**Planning Act 2008 – Application by NNB Generation Company (SZC) Limited for an Order Granting Development Consent for The Sizewell C Project**

**Summary of Marine Management Organisation (“MMO”) comments on the detailed agenda for Issue Specific Hearing (“ISH 11”) on Flooding, Water and Coastal Processes.**

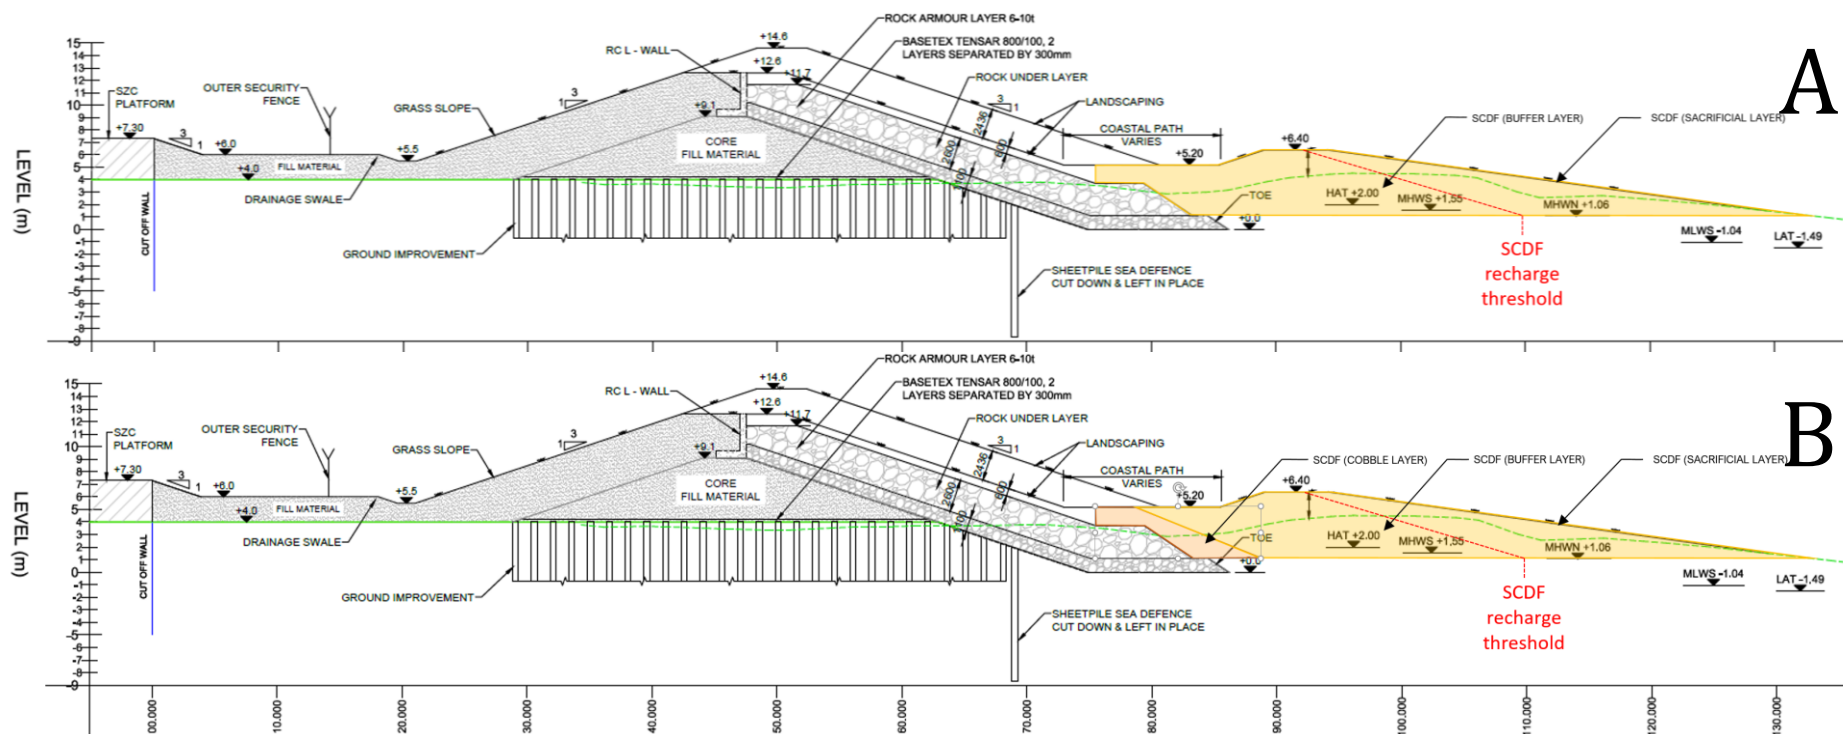
- 3.1 Based on the SCDF modelling that the MMO have reviewed [REP2-115 and REP3-048] the MMO cannot conclude that there will not be a negative impact on the neighbouring coastline and nearshore morphology caused by the SCDF if a much coarser material is used for the sacrificial outer layer, in comparison to the native sediment in the area. See our detailed comments on this in section 5.1 of REP6-039, and section 3.1 of REP6-040.

- 3.2 As a result of our review of the modelling for the SCDF, the MMO does not agree that using coarser material for the sacrificial outer layer of the SCDF is the best option at this stage. The modelling concludes that the use of a finer sediment will only involve a limited number of recharges (6 or 7 times over the course of the operational phase), and therefore the MMO does not consider that the use of a much coarser material is justified based on the concerns we have raised.
